**Re: 123 Cumberland Ave**

The site plan and landscape plan that were submitted as part of the application are different from the one attached to this original e-mail. I see the numbers that are provided on site plan C1.2 - Rachel Conly Design, LLC, but I am not clear how this corresponds to the other 2 plans and the existing conditions of the survey. I look forward to your clarification.

SITE PLAN  
 C1.2

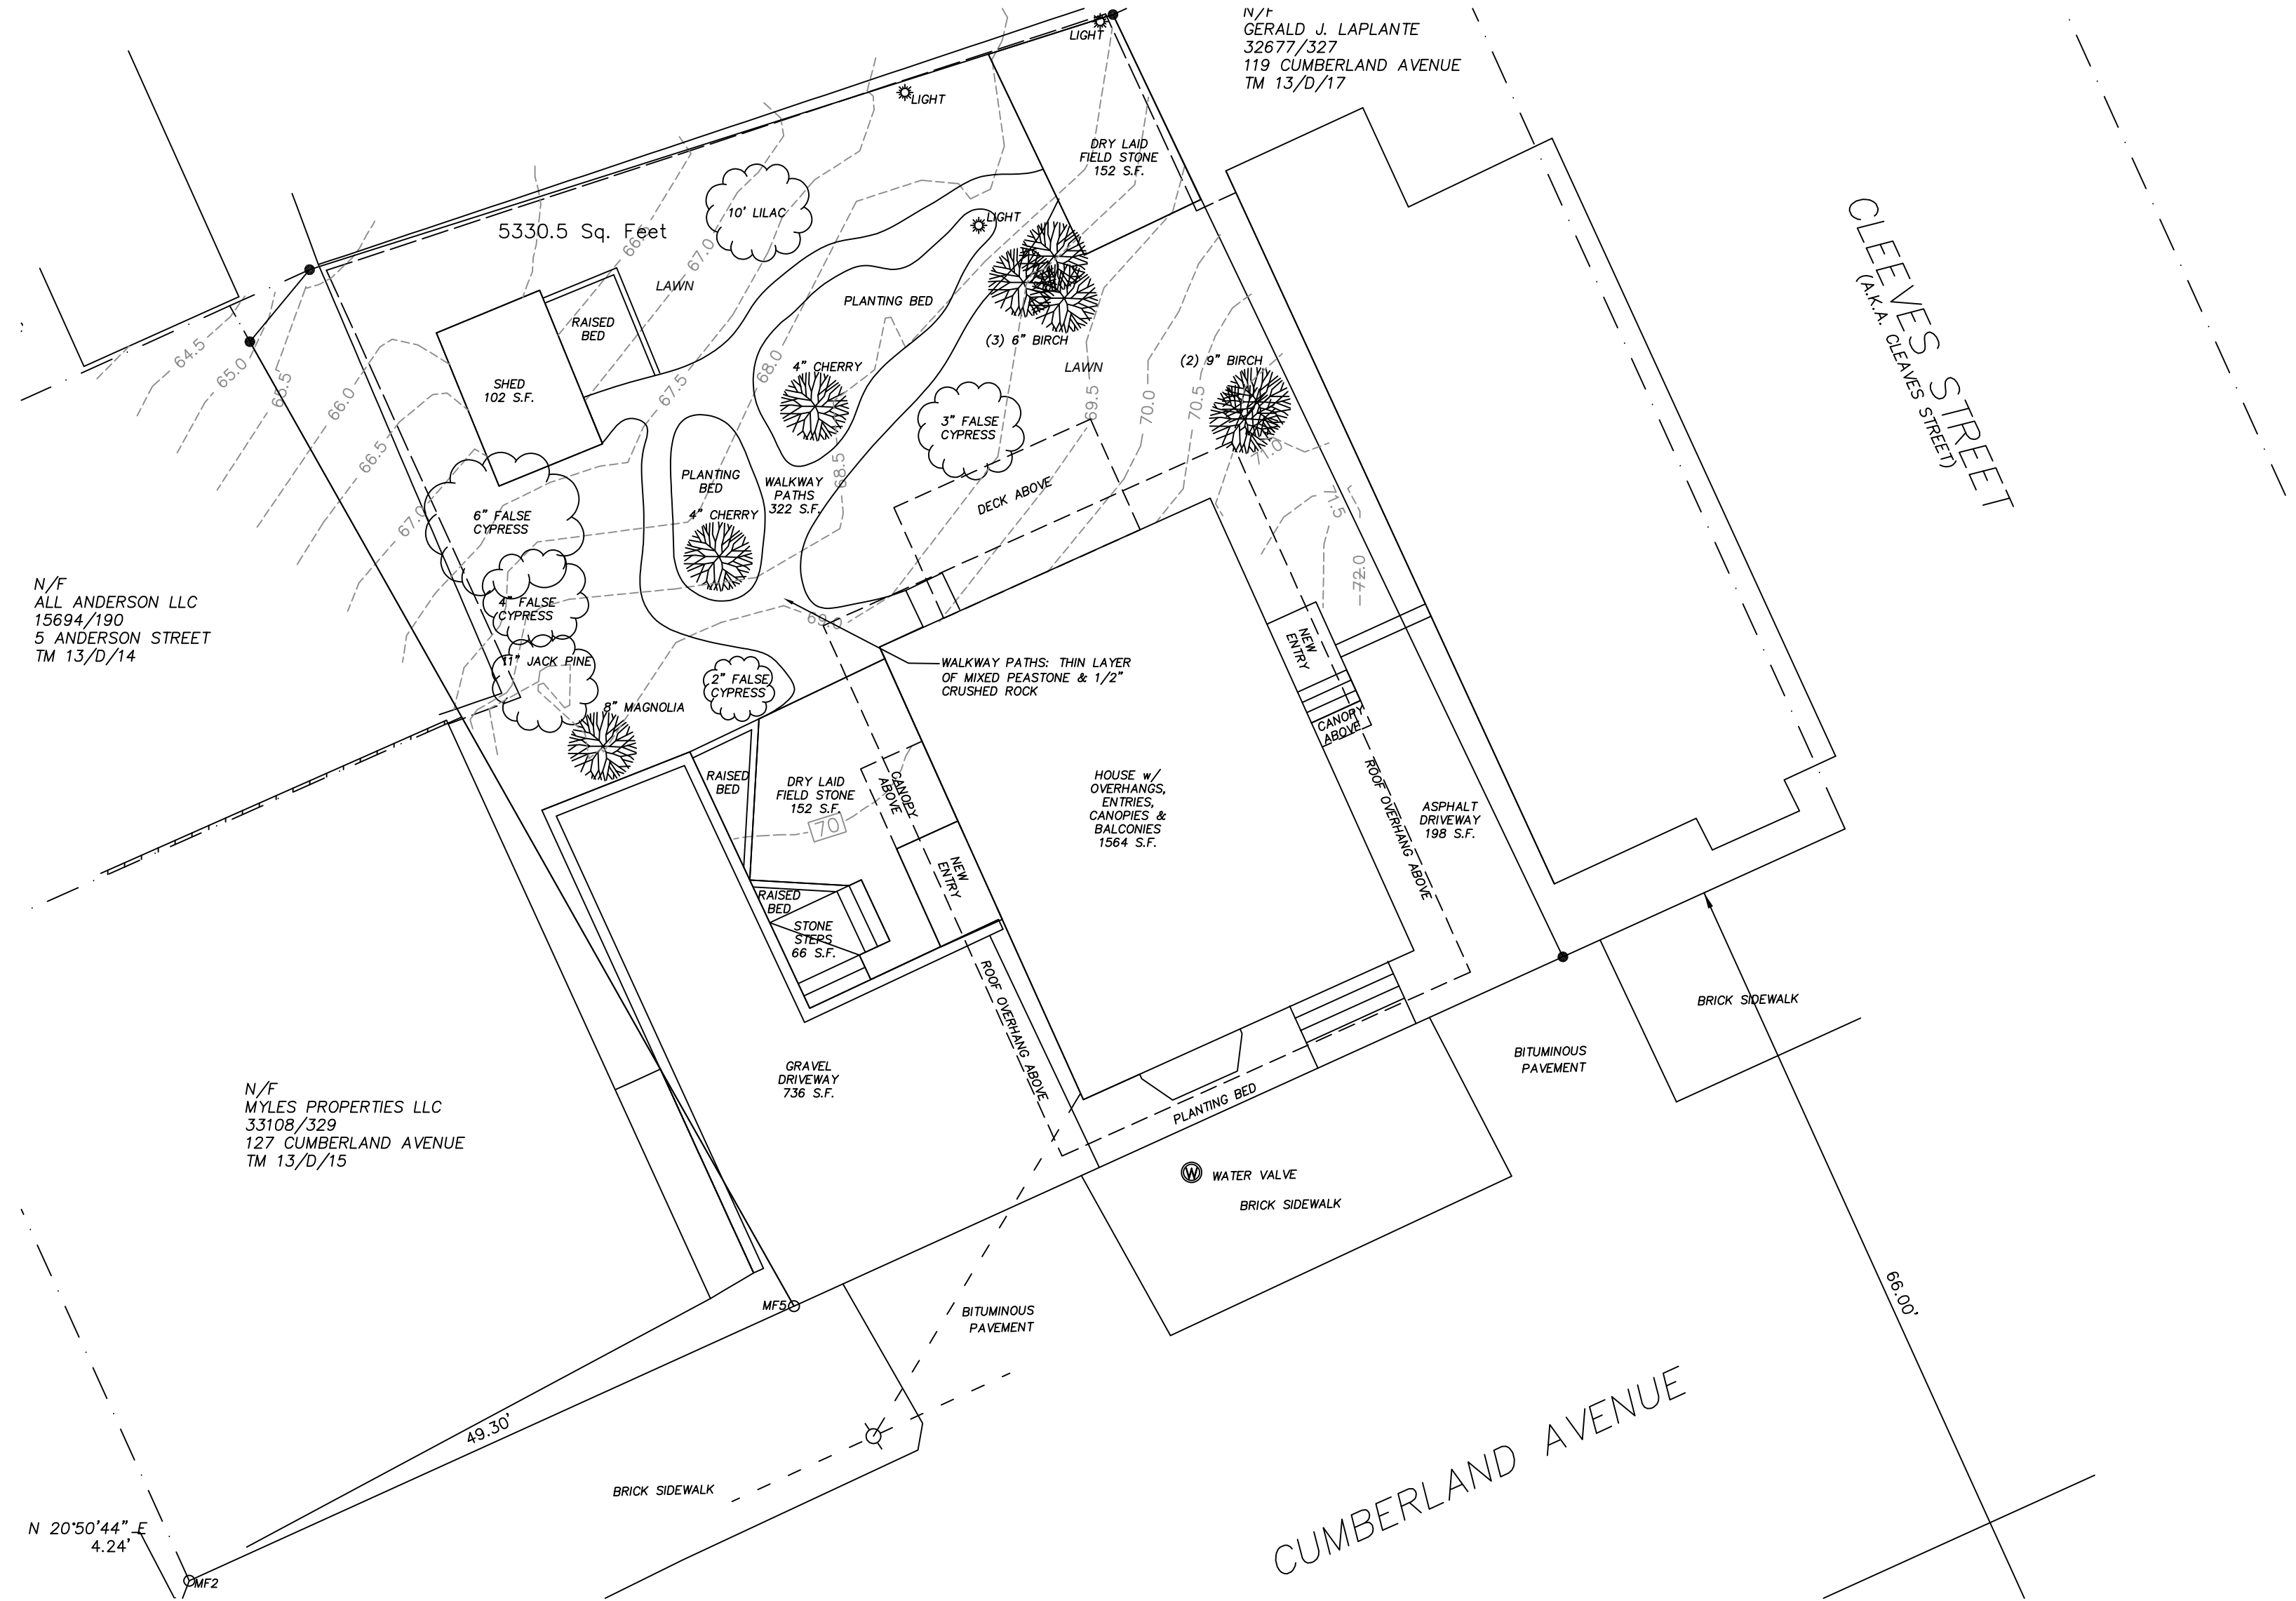
1. The site data put into CSS says the existing impervious area is 3,290 and that the proposed is 3,190. Is the total new impervious surface area for the garage, patios and walks a total of 3,190? I notice on the site plan the patio and steps are

- noted as proposed concrete where as the Landscape plan shows some of this area as sod. Please clarify
2. What is the purpose of the gravel area at the back of the property with the gate at the property boundary?
  3. The site plan shows a mini-drywell and an infiltration area. I don't see a stormwater management plan as one of the submissions. Based upon the site plan, it appears that over 1,000 sf of new impervious surface area is being added and thus a stormwater management plan is required.

No the original survey did not show how much impervious surface exists. However when the first permit was sought for renovations to the two side entries and interior of the home, the city requested a site plan with more detail about what existed in the backyard. We took the measurements of length and widths of paths and dimensions of the two patios, (the one at the NE corner and the patio between the retaining wall and the entrance to the basement apartment) and drafted the results as an overlay on the survey.

Computer generated area calculations of all impervious produced the figure present in our application.

1. The impervious surface is +/- 10 sf less than before development. Please see attached plan, which accompanied our first submission to the city for renovations to both side entries and the interior of the house. I will upload this as soon as I hear from Jen. There is a shed, a large patio and a somewhat extensive system of pathways in the rear yard and both sides of house are and will remain impervious. Re sod and concrete disparity, would you please clarify?

**BOUNDARY SURVEY OF LAND  
123 CUMBERLAND AVENUE  
PORTLAND, MAINE**

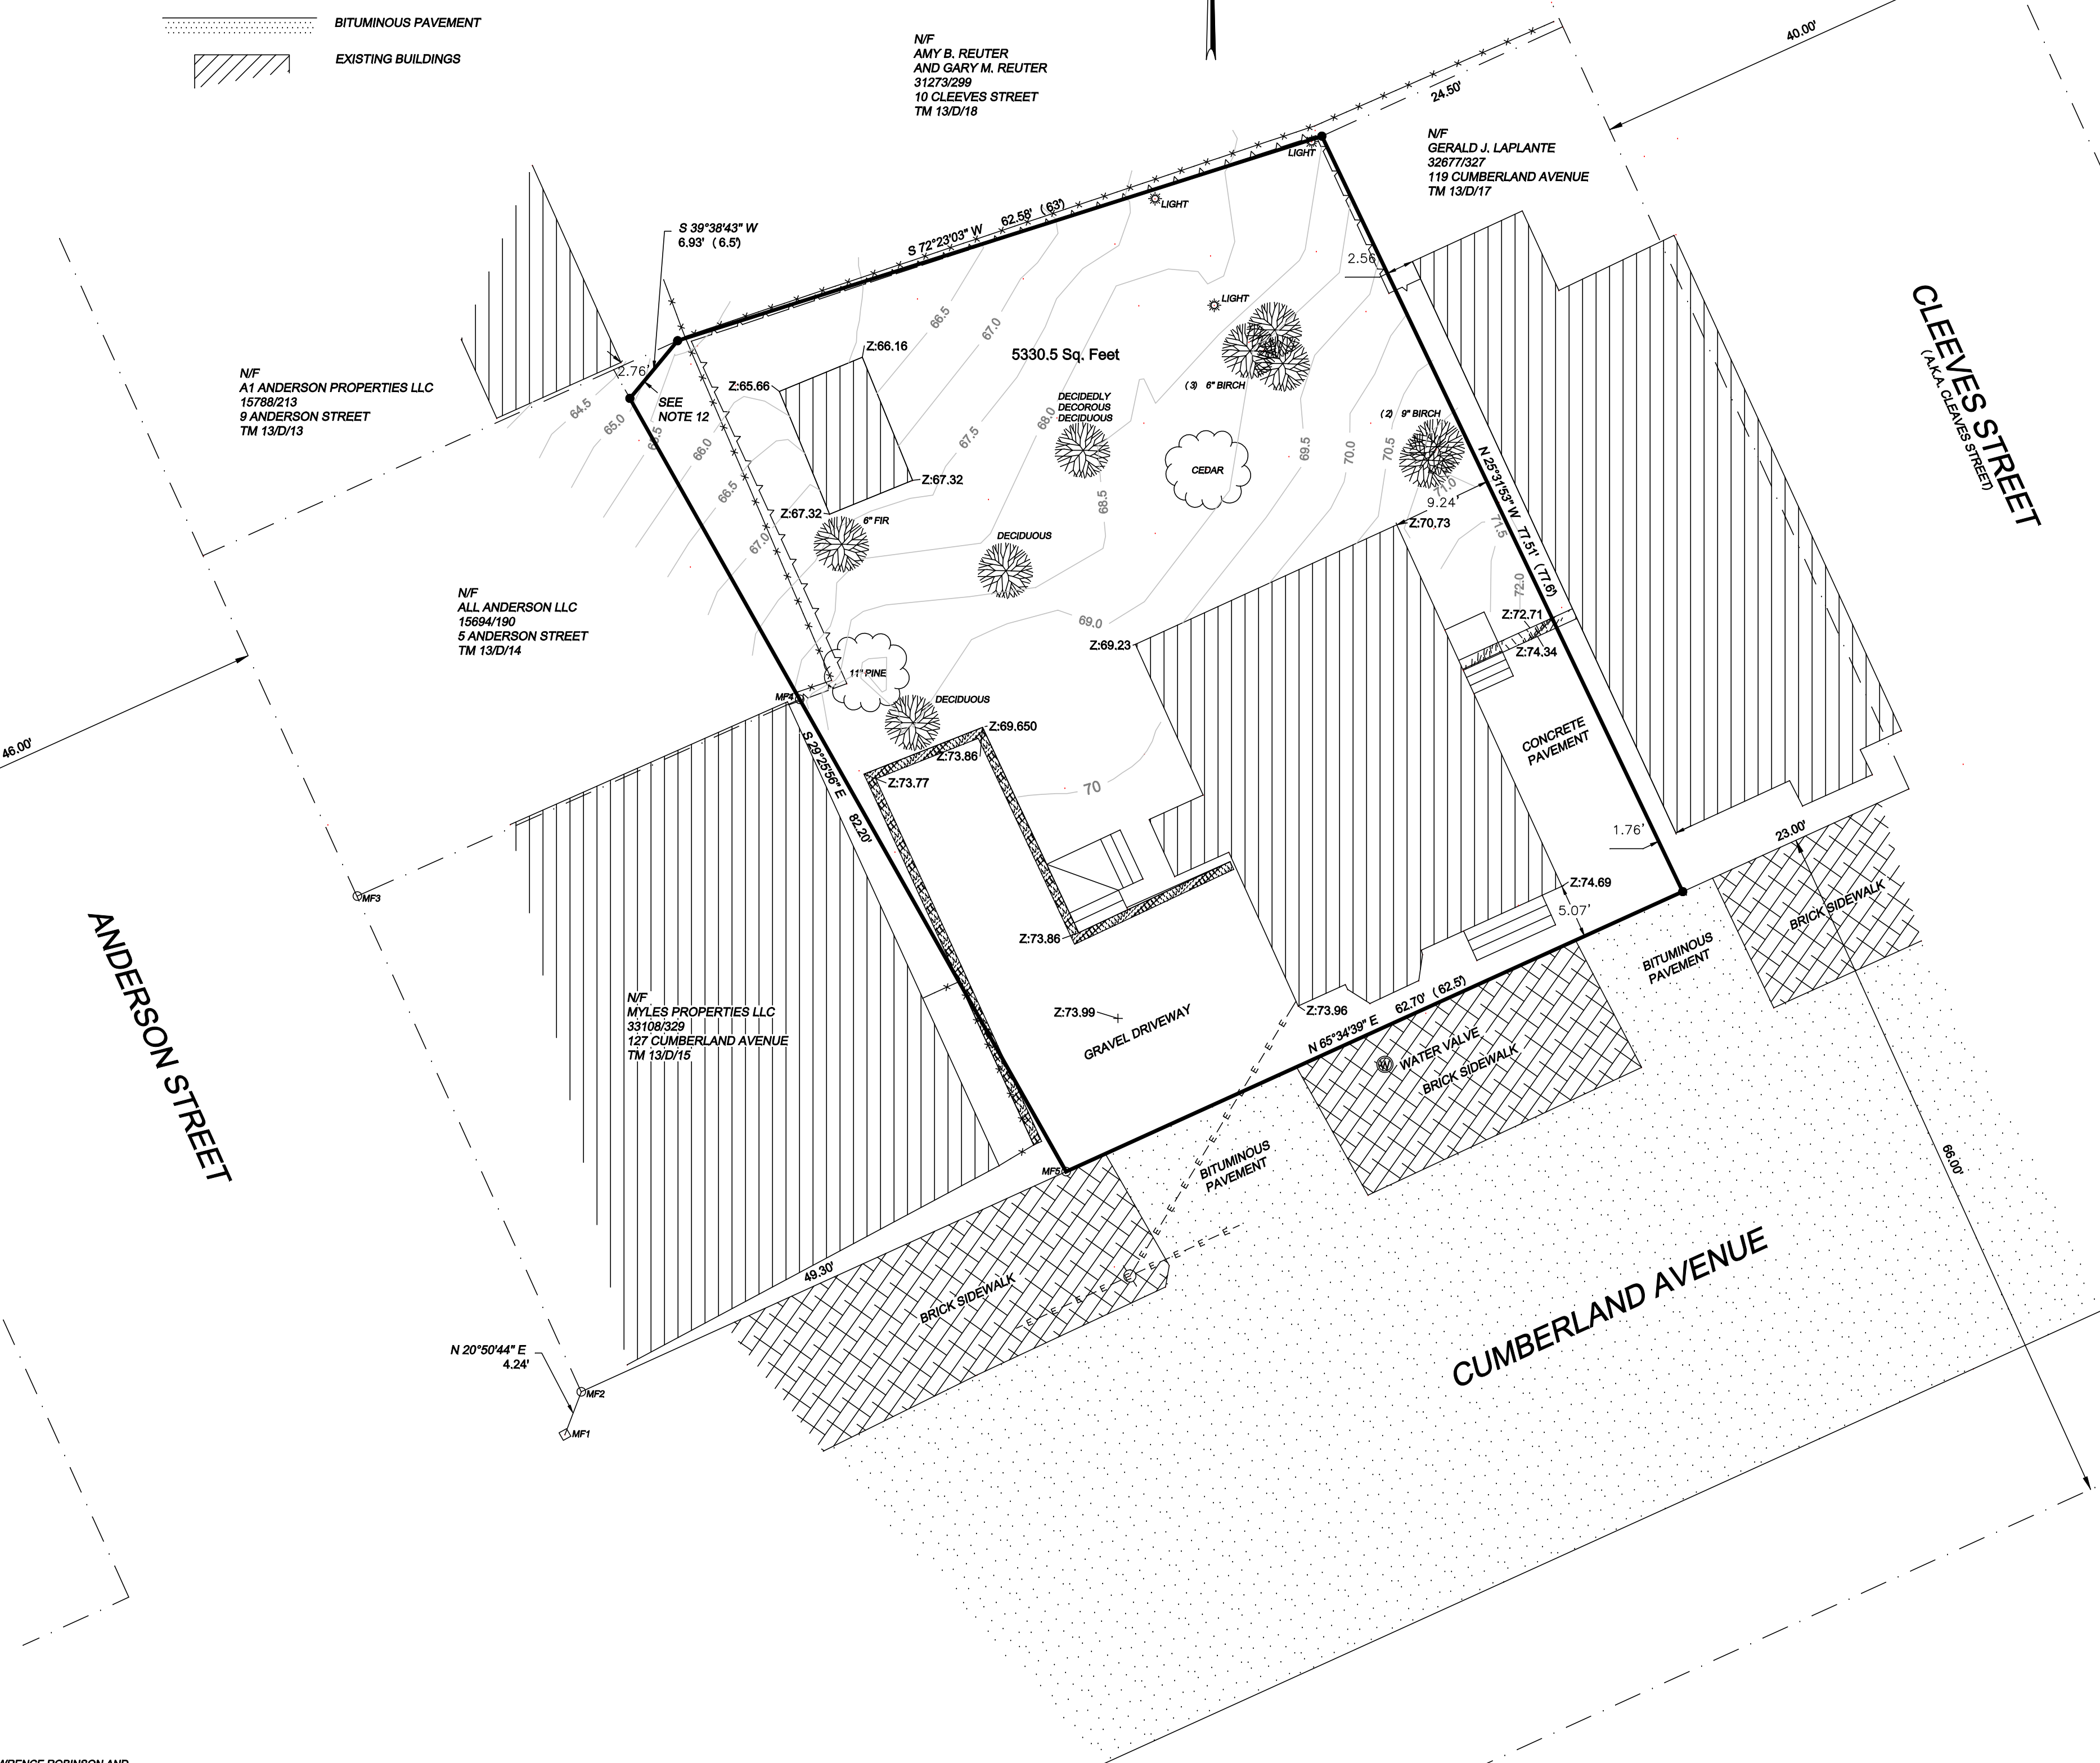
I am attaching the boundary survey that I received with the application. It does not state the amount of impervious coverage of the site.
